Addendum No. 1

RE: Contract ID C202951

Davidson County (B-4497)

Bridge Over US-29/70 and I-85 Business on US-64

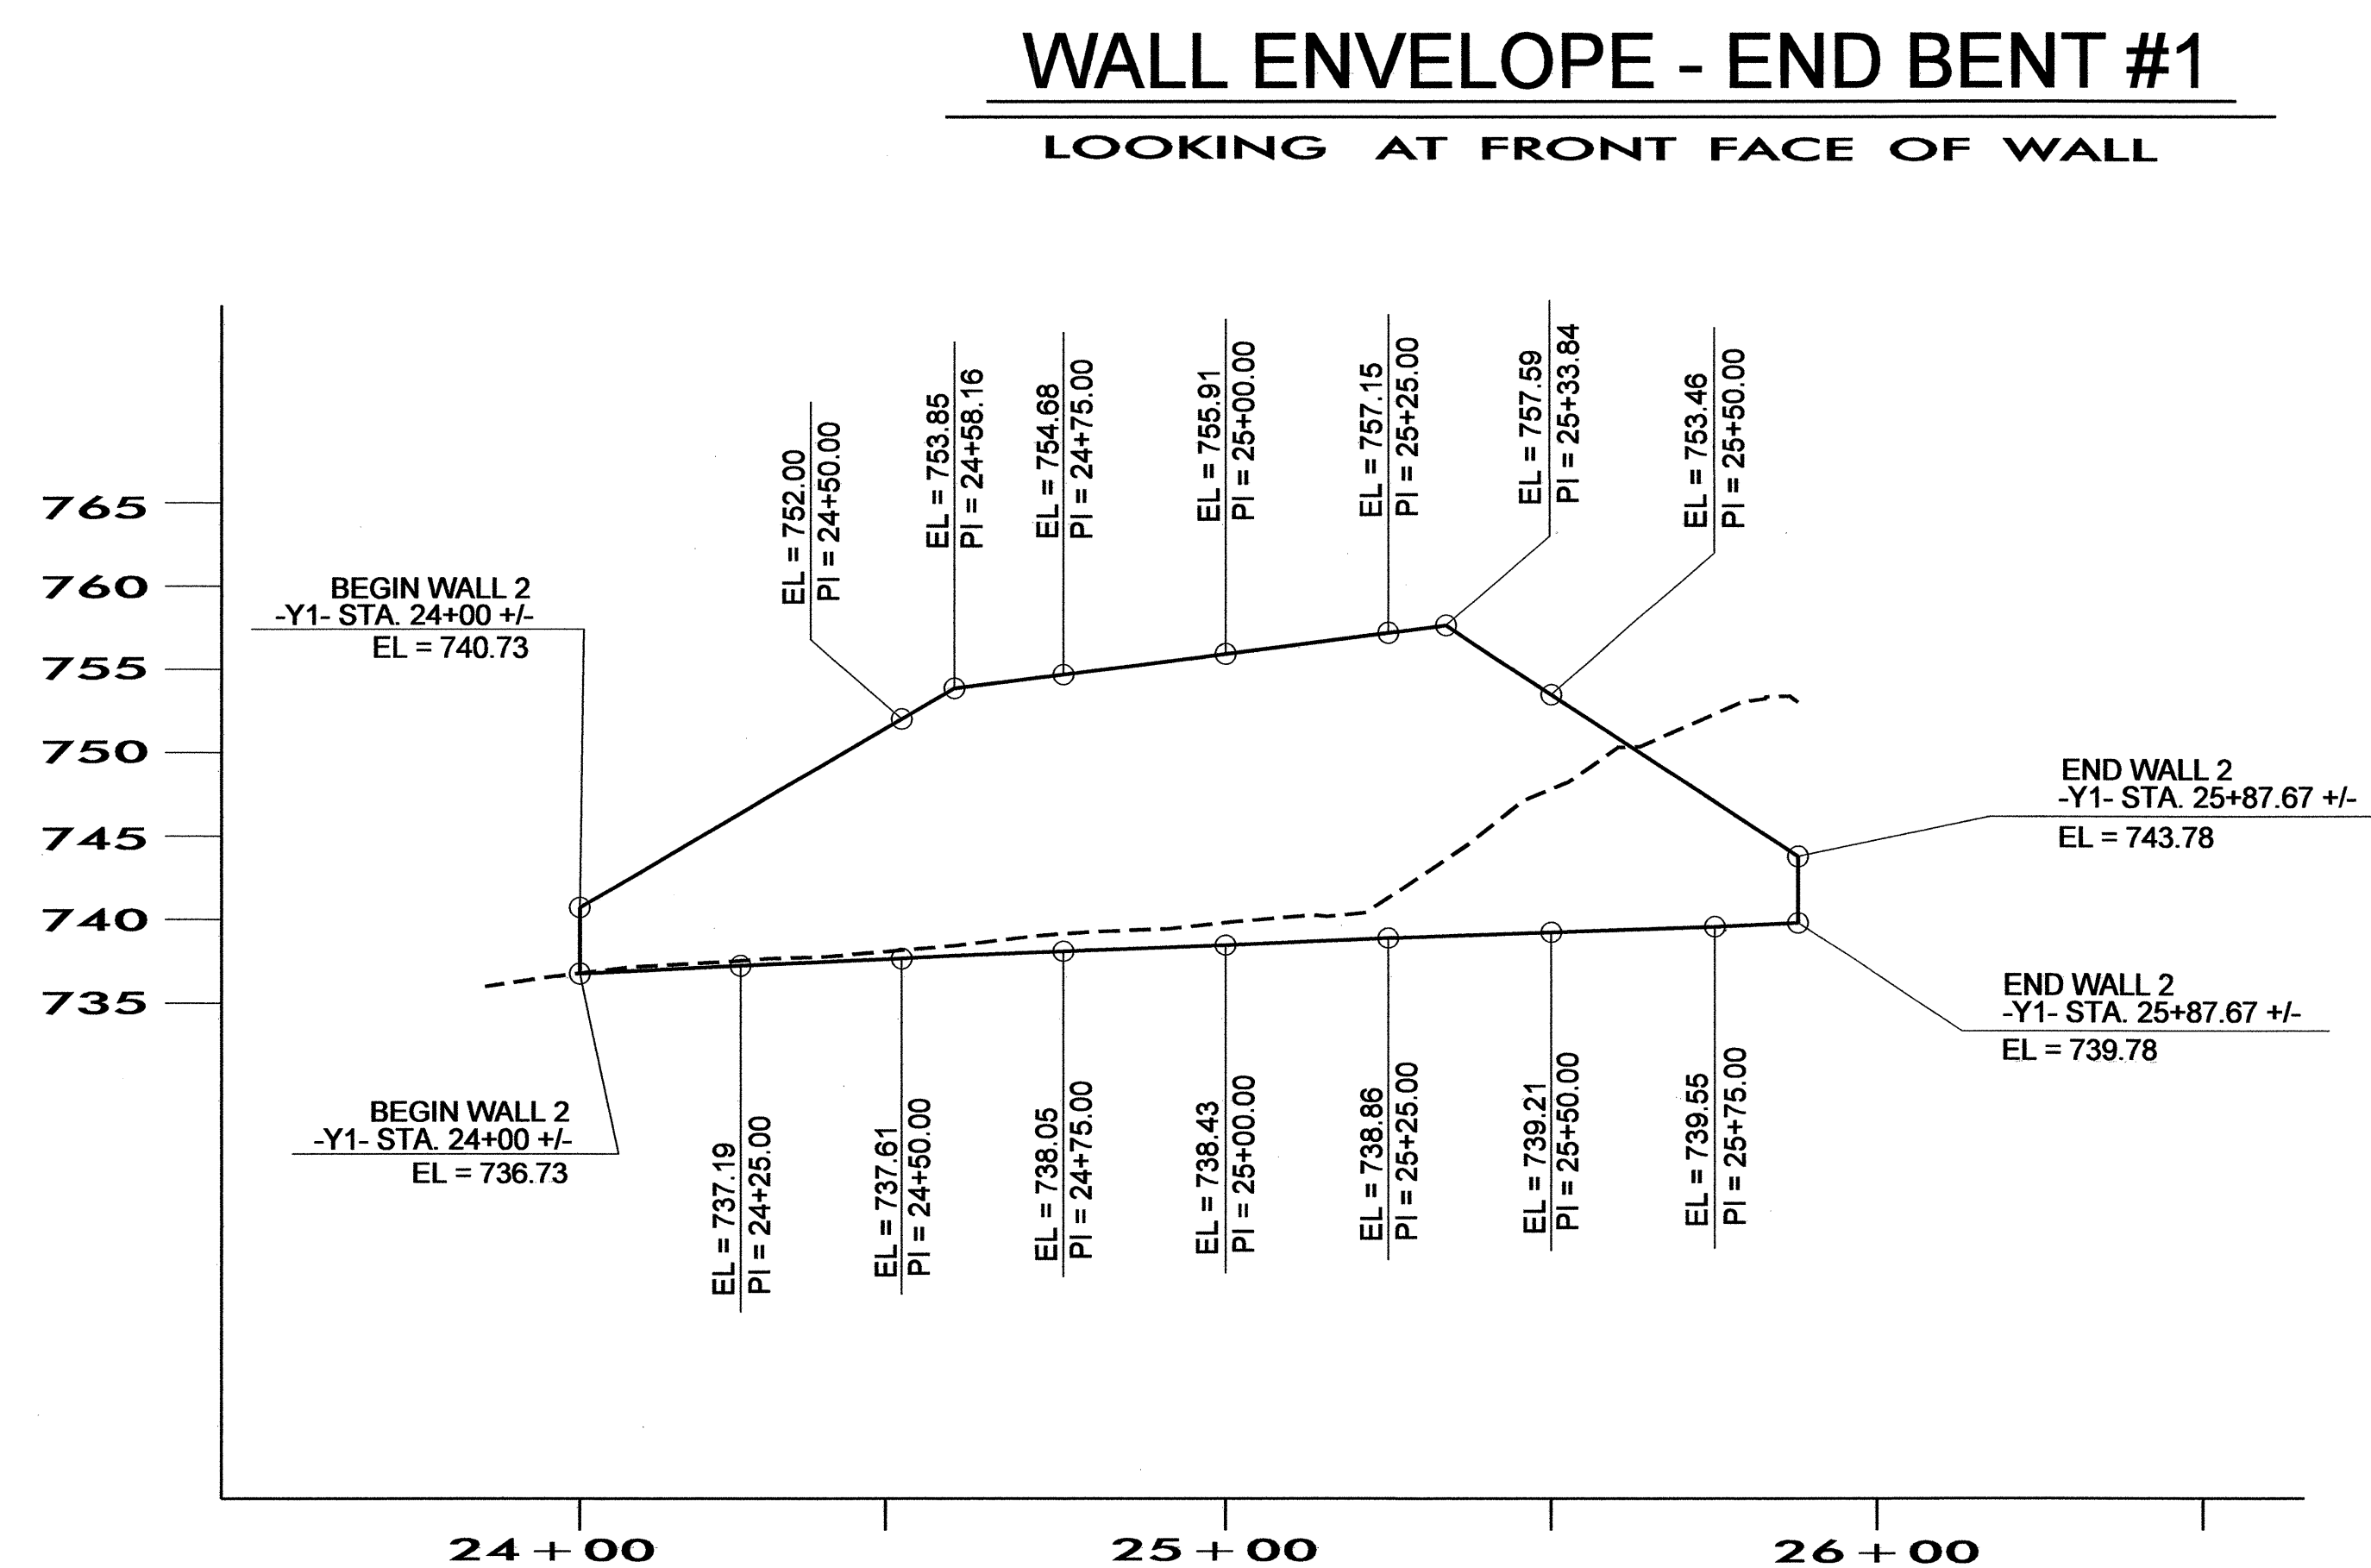
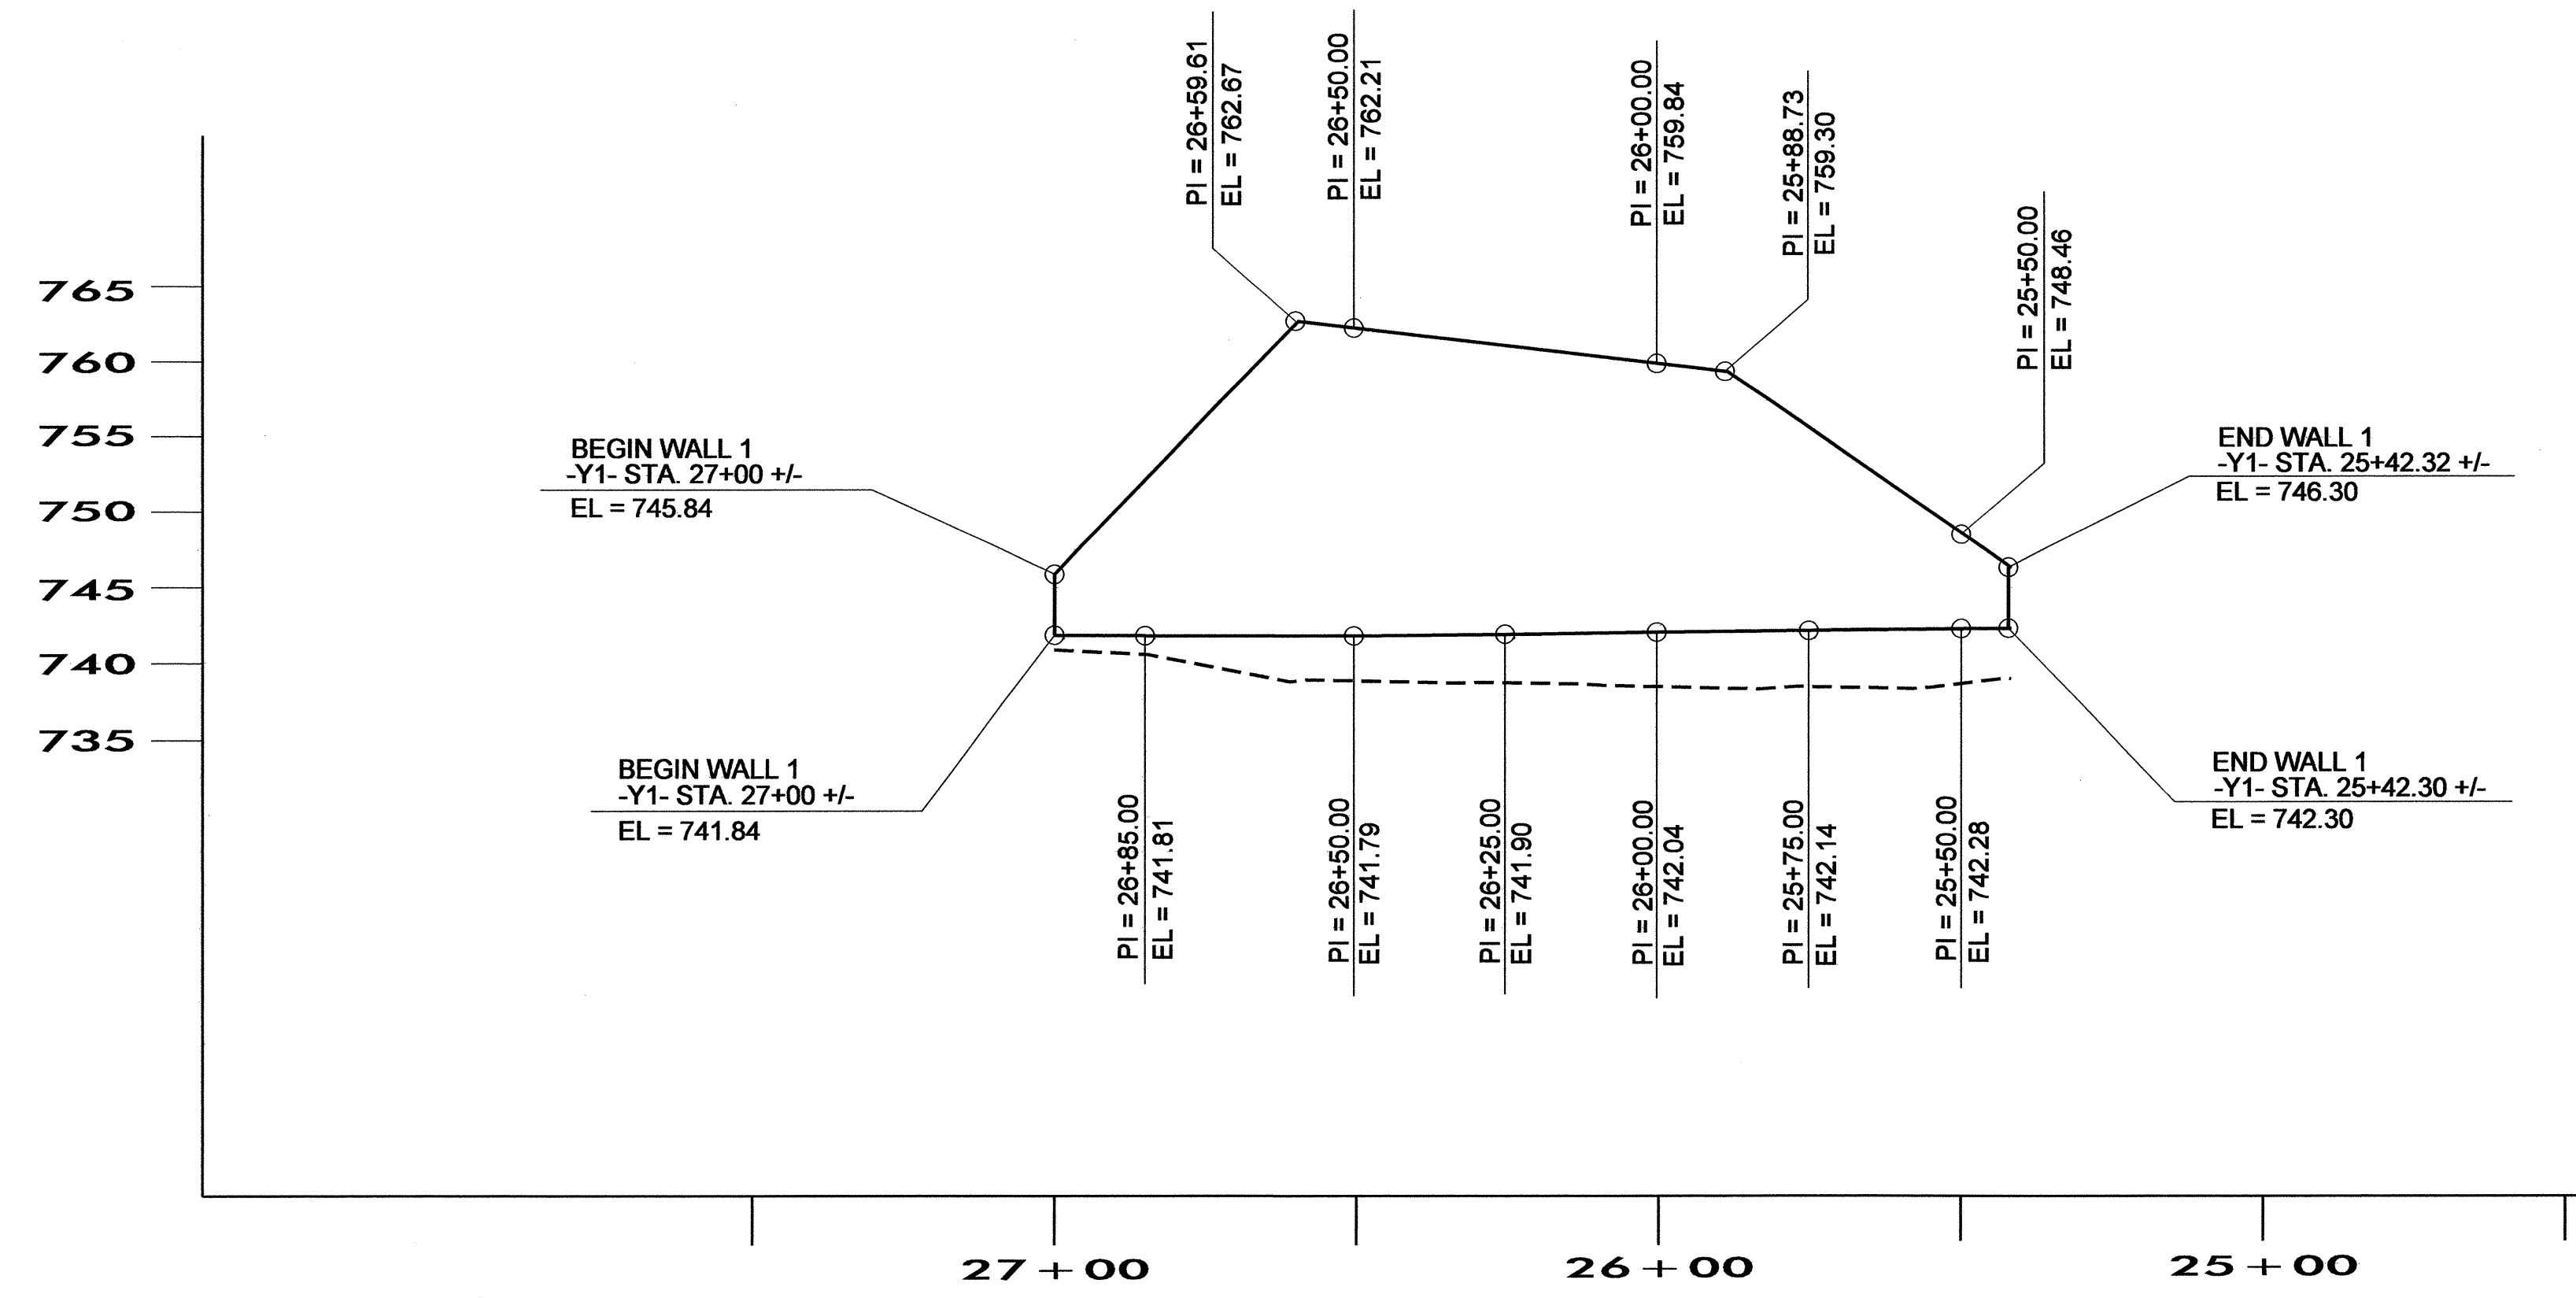
On Sheet No. W-3 the "Factored Load" value and one dimension have been revised. On Sheet No. W-4 a note has been revised. Please void Sheet Nos. W-3 and W-4 in your plans and staple the revised Sheet Nos. W-3 and W-4 thereto.
